Application by Morecambe Offshore Wind Limited for Morecambe Offshore Windfarm Generation Assets

The Examining Authority's additional written questions and requests for information (ExQ3)

Issued on 25 March 2025

8 Liverpool Bay SPA with 2.4nm CPP1 WTG and OSP Aviation Buffer and 2.4nm Calder WTG and OSP Buffer

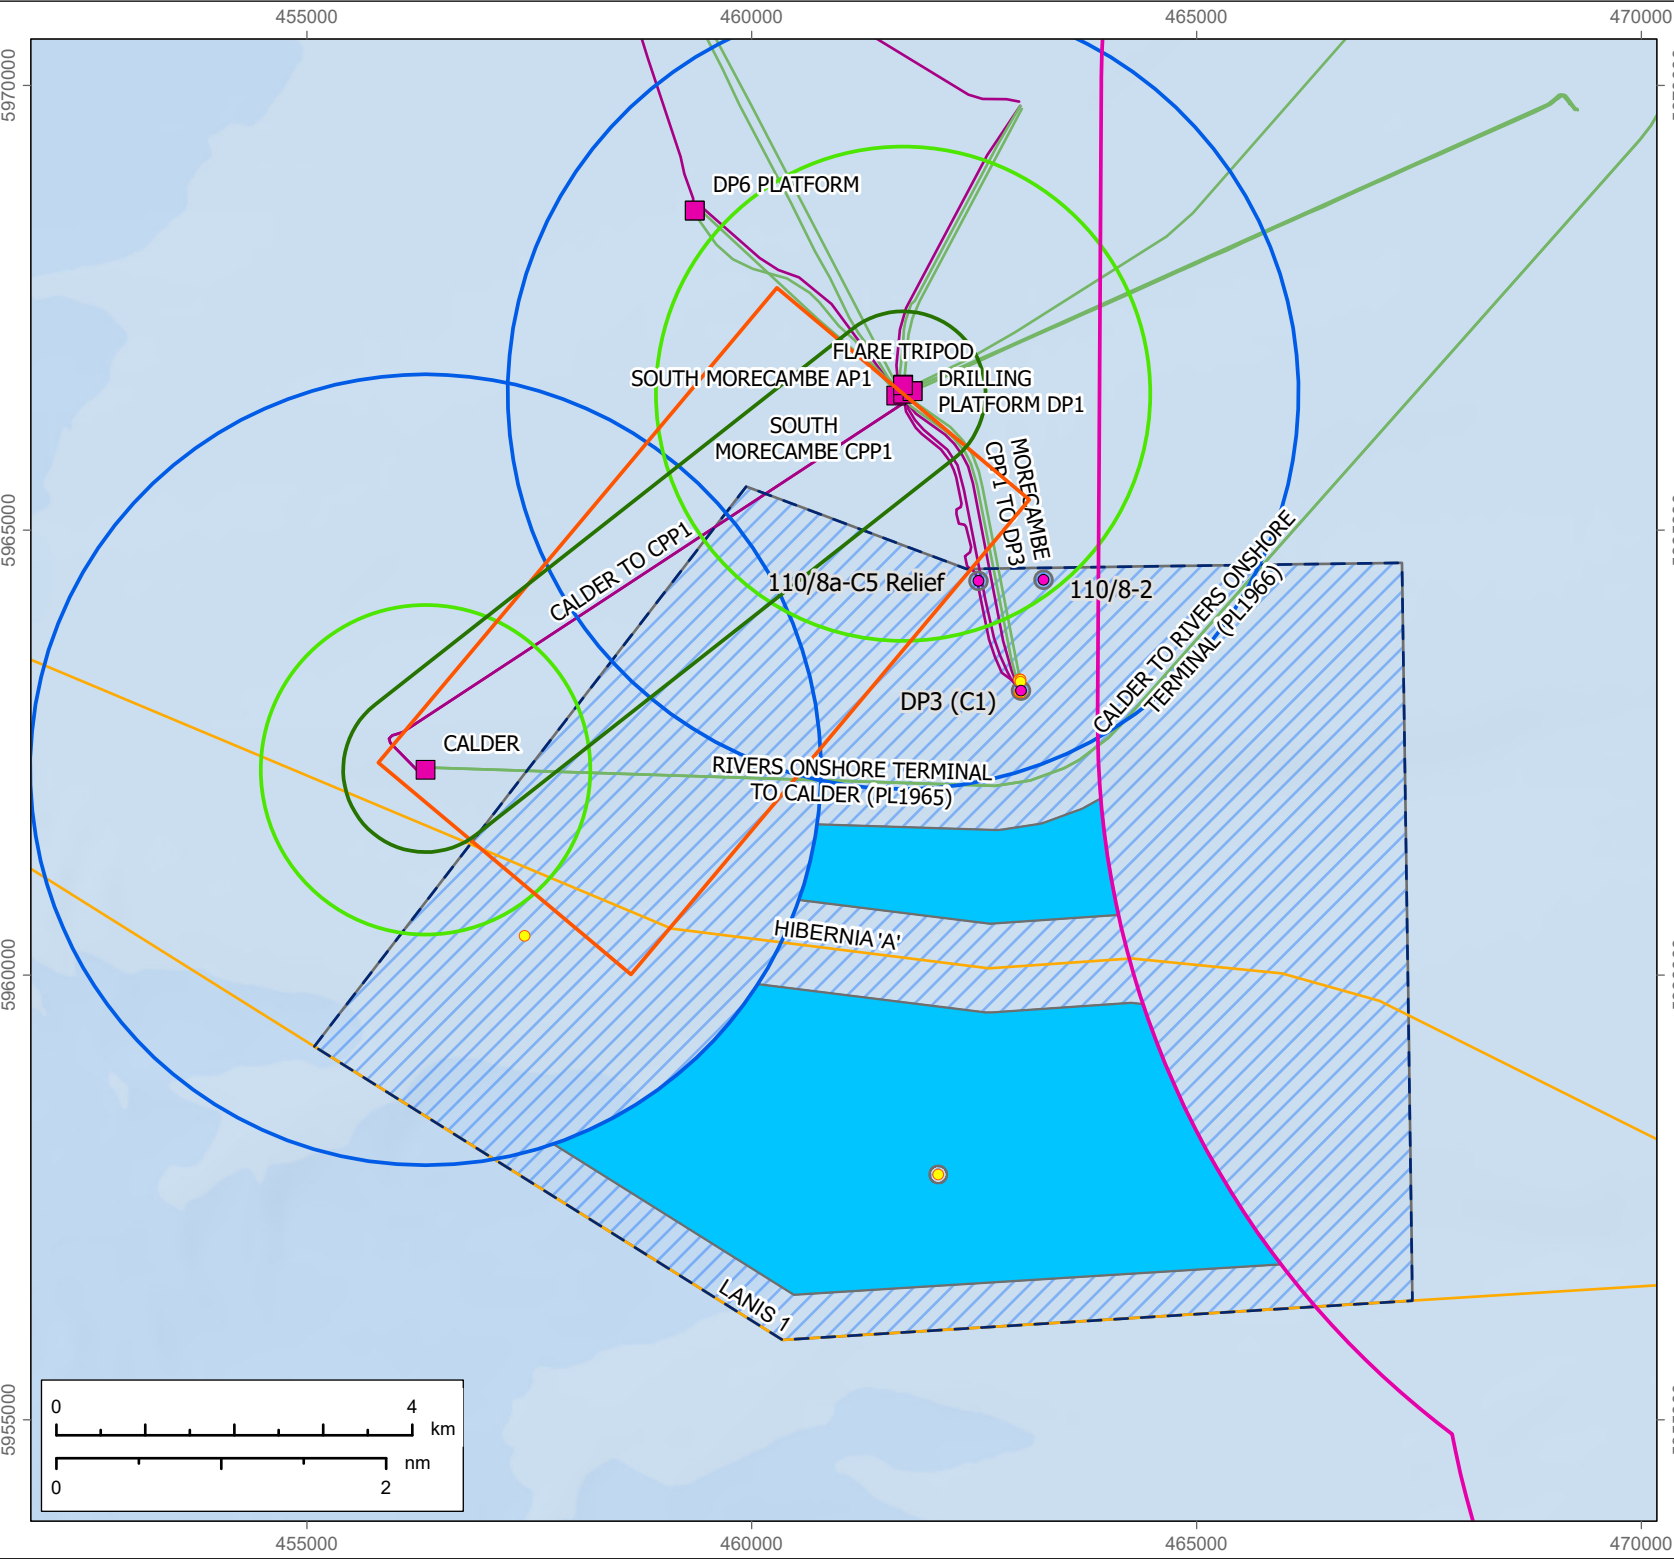
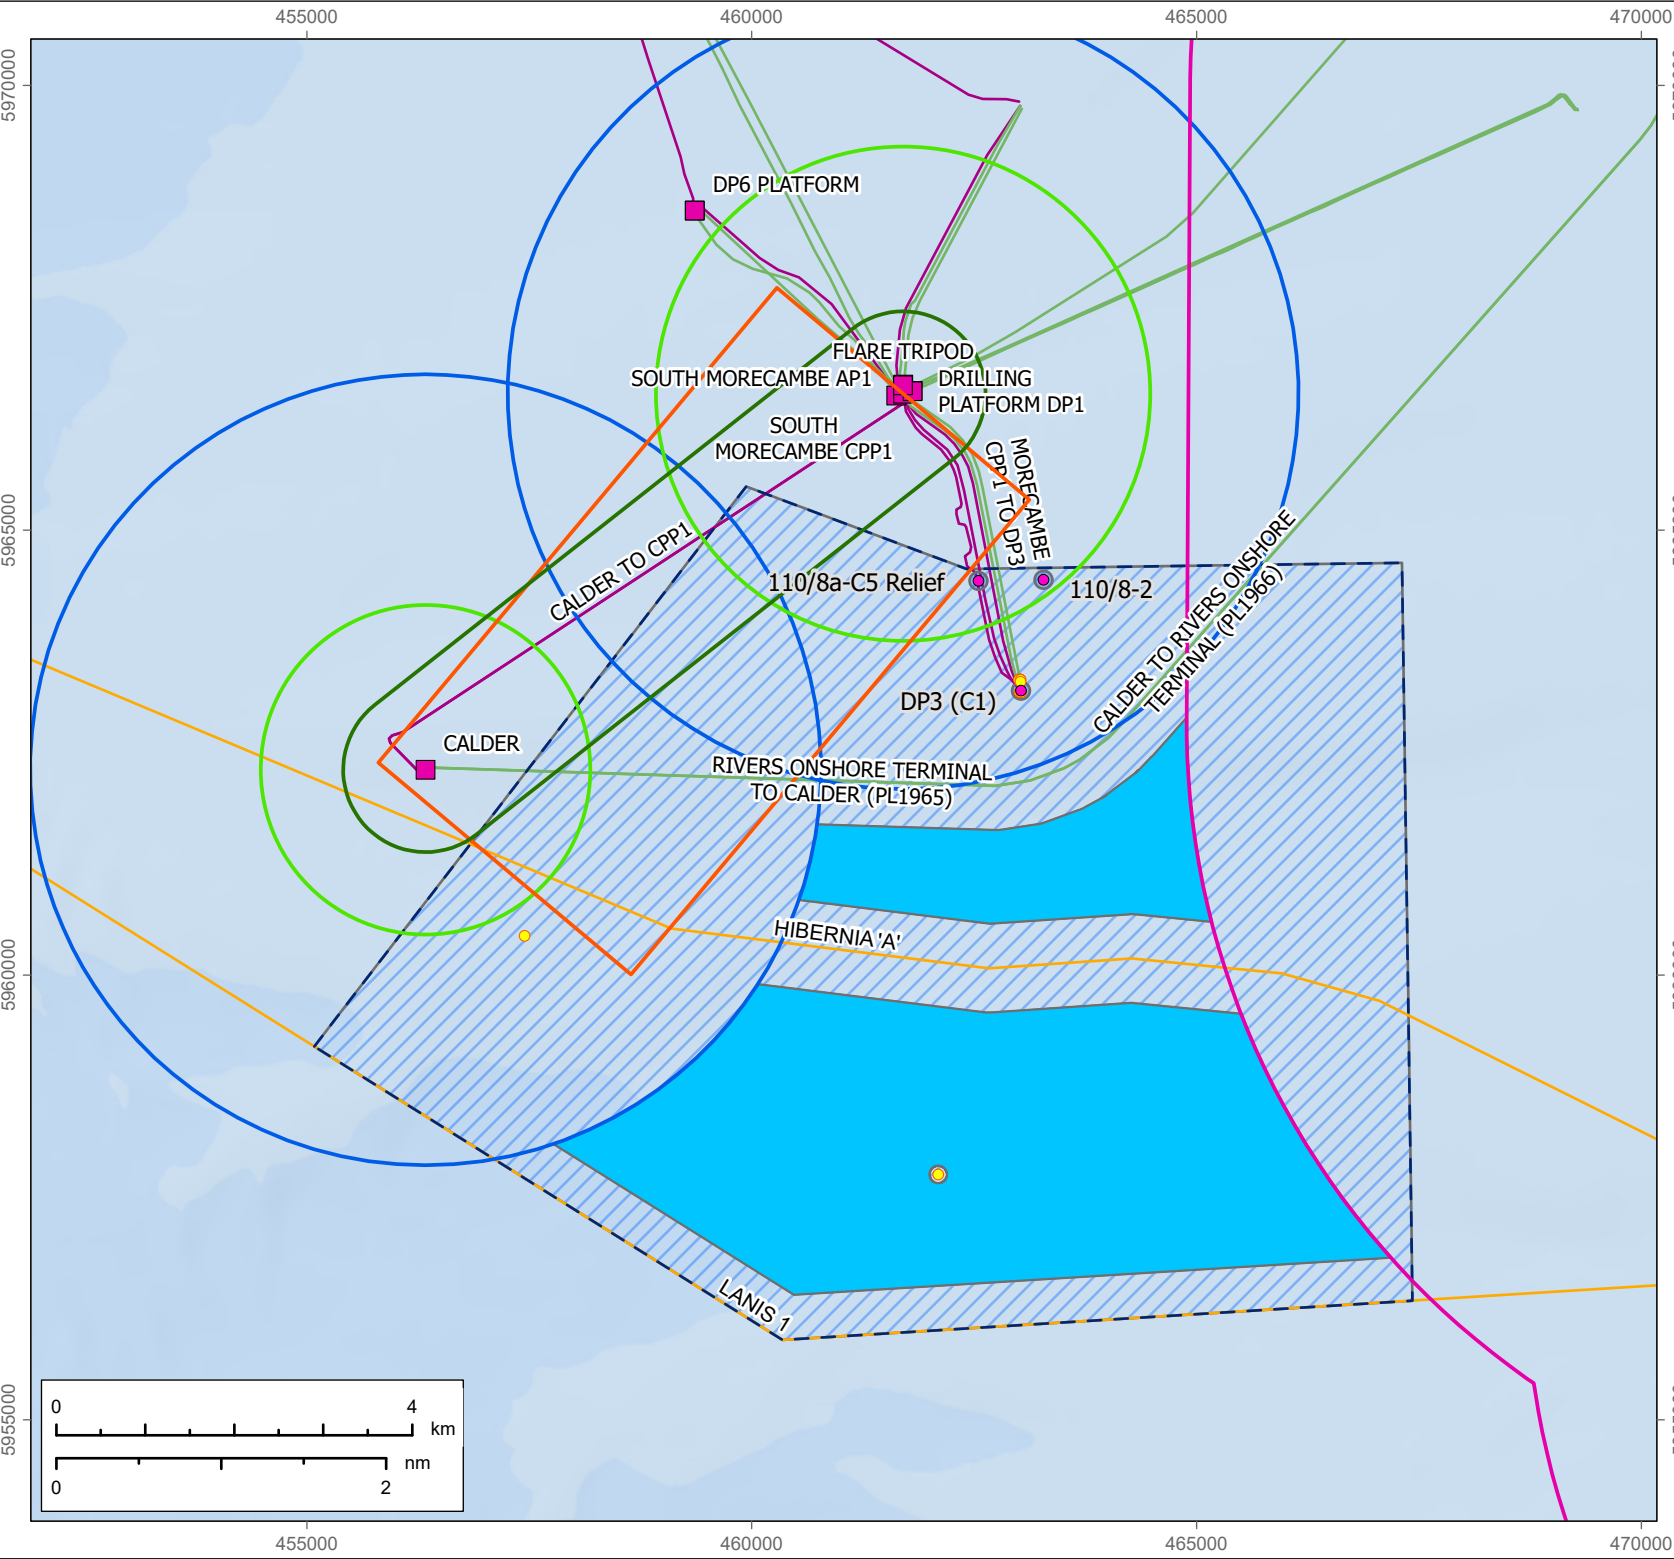
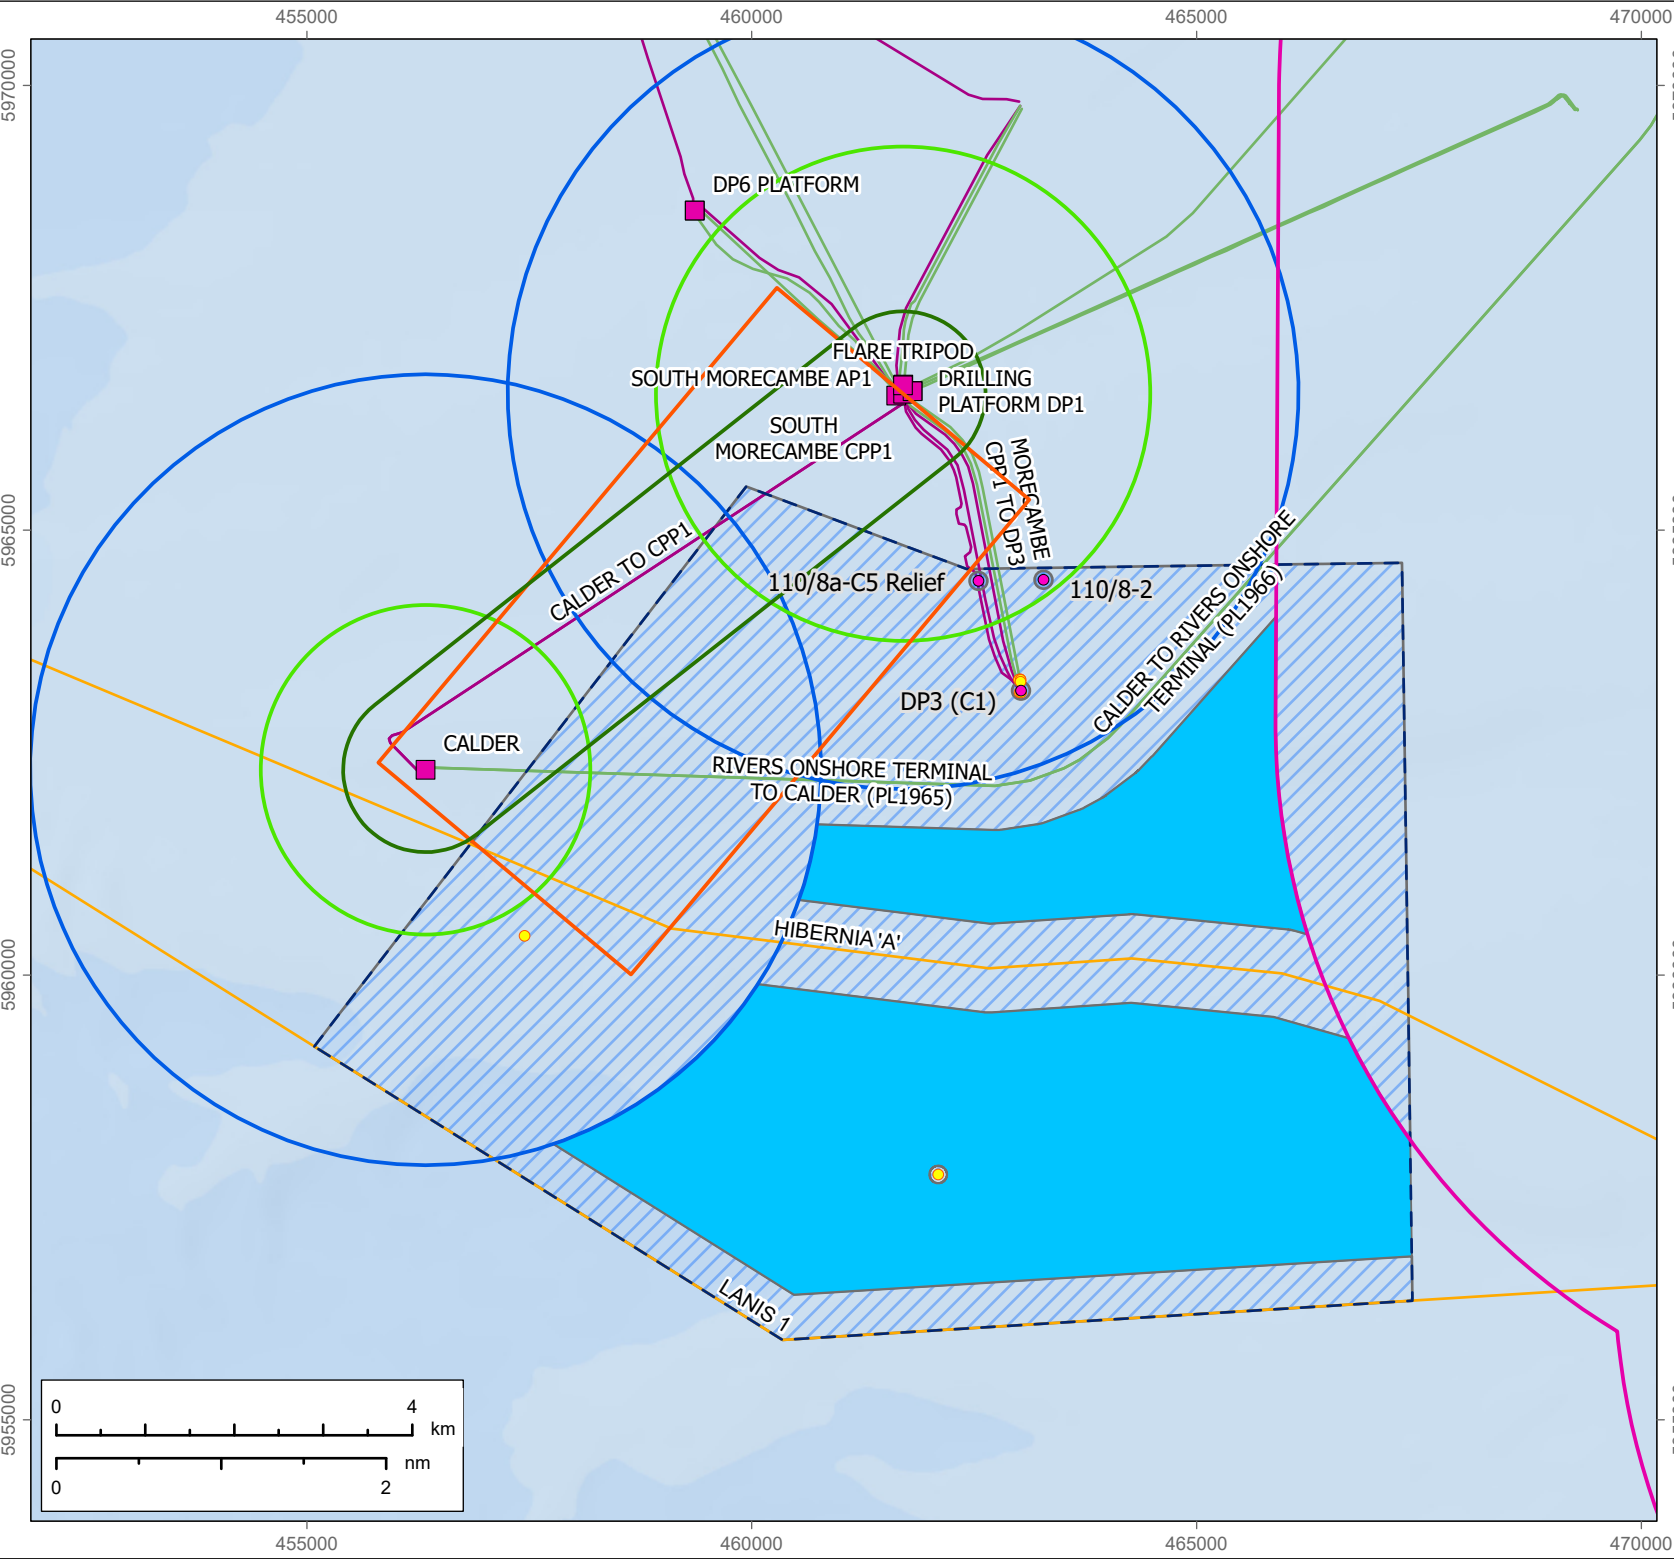
ExQ3	Question to:	Question:										
3GEN3.	The applicant	<p>Liverpool Bay SPA and Oil and Gas Platform Buffers</p> <p>Whilst the ExA notes the caveats stated in the applicant’s response to ExQ2HRA6 at D5 [REP5-070], to further demonstrate and support the applicant’s position:</p> <p>a) please can the applicant provide individual plans to demonstrate the impact that each of the incrementally smaller buffers from the original Liverpool Bay SPA would have on the layout and number of WTGs that could be accommodated within the site (i.e. 10km, 9km, 8km, 7km and so no buffer associated with the SPA affects the site) - with all other existing buffers/ corridors as shown on [REP5-007] unchanged.</p> <p>b) in Spirit Energy’s response to ExQ2CAR5 at D5 [REP5-090] it advises a buffer distance of 1.9nm is the minimum acceptable requirement for safe landing and take-off in daytime VMC and for night VMC this distance would be 2.4nm. In light of this could the applicant provide plans for each alternative SPA buffer scenario in (a) plus each of the increased buffer scenarios from the Calder and CCP1 platforms as set out in the following table.</p>

<table><tr><th><u>CPP1 WTG and OSP Aviation Buffer</u></th><th><u>Calder WTG and OSP Buffer</u></th></tr><tr><td>2.4nm</td><td>2.4nm</td></tr></table>

<p>c) any additional comments or further information the applicant wishes to provide on the implications of each of the above scenarios (noting the applicant’s previous response [REP5-070], EXQ2HRA3 and 2HRA6].</p> <p>The ExA is seeking a complete set of alternative scenarios shown on plans, so that, whatever the SoS may determine, if they felt it was appropriate they could include the relevant plan within any final DCO without having to revert to the applicant for that plan. Each should therefore have a different drawing number.</p>	<u>CPP1 WTG and OSP Aviation Buffer</u>	<u>Calder WTG and OSP Buffer</u>	1.9nm	1.9nm	2.4nm	1.9nm	1.9nm	2.4nm	2.4nm	2.4nm
<u>CPP1 WTG and OSP Aviation Buffer</u>	<u>Calder WTG and OSP Buffer</u>											
1.9nm	1.9nm											
2.4nm	1.9nm											
1.9nm	2.4nm											
2.4nm	2.4nm											
3GEN4.	The applicant	<p>Design Statement - Cabling</p> <p>Could the applicant please explain why (former) provision DC15 relating to use of the most direct/ efficient cabling route to minimise cutting has been deleted from the post-consent design code in Table 6.1 of the Design Statement [REP5-008] and [REP5-009].</p>
